9th September 2020

I understand that you would like Boultons to clarify earlier advice on the fire safety benefits of removing the rear extension to the above property.

PROPOSED ALTERATIONS TO REAR ELEVATION

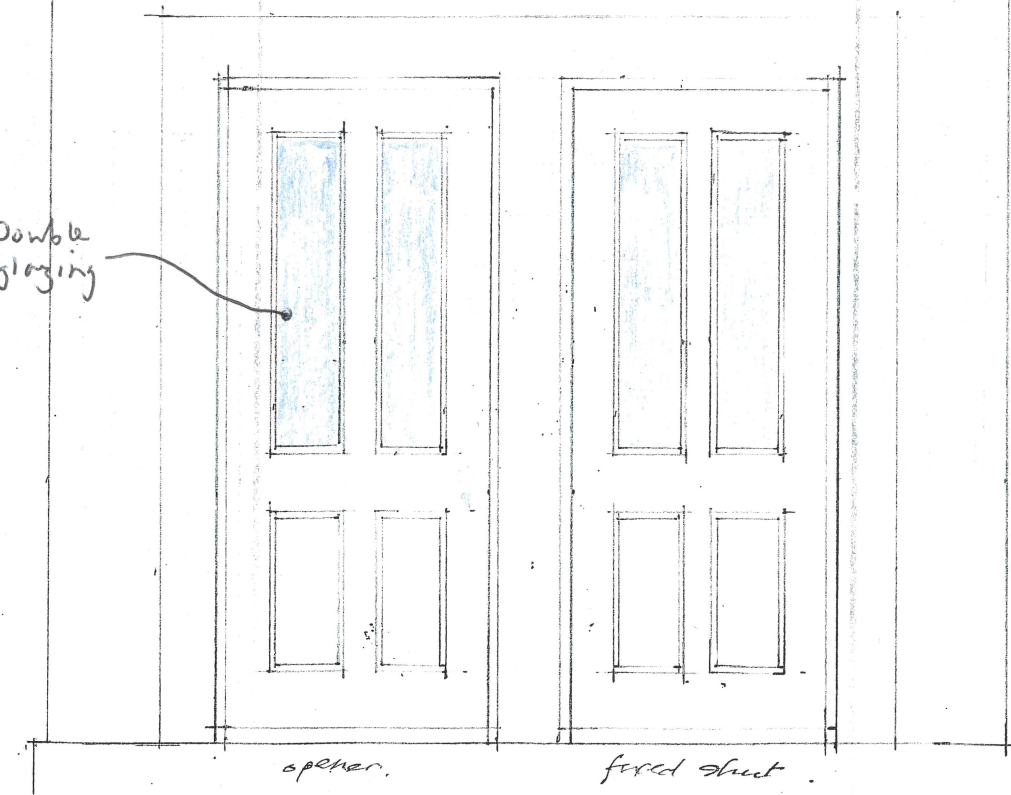
Following removal of the extension, the balcony to the rear will be joined and this will provide the ground floor right hand office with a secondary and alternative means of escape in the event of a fire. This is undoubtedly a better fire provision than existing for this section of the building.

A second door to the current toilet block extension on the south side would not assist in this respect. Egressing into the extension generally before any new openings is not the same as leaving through one exit straight into the open air.
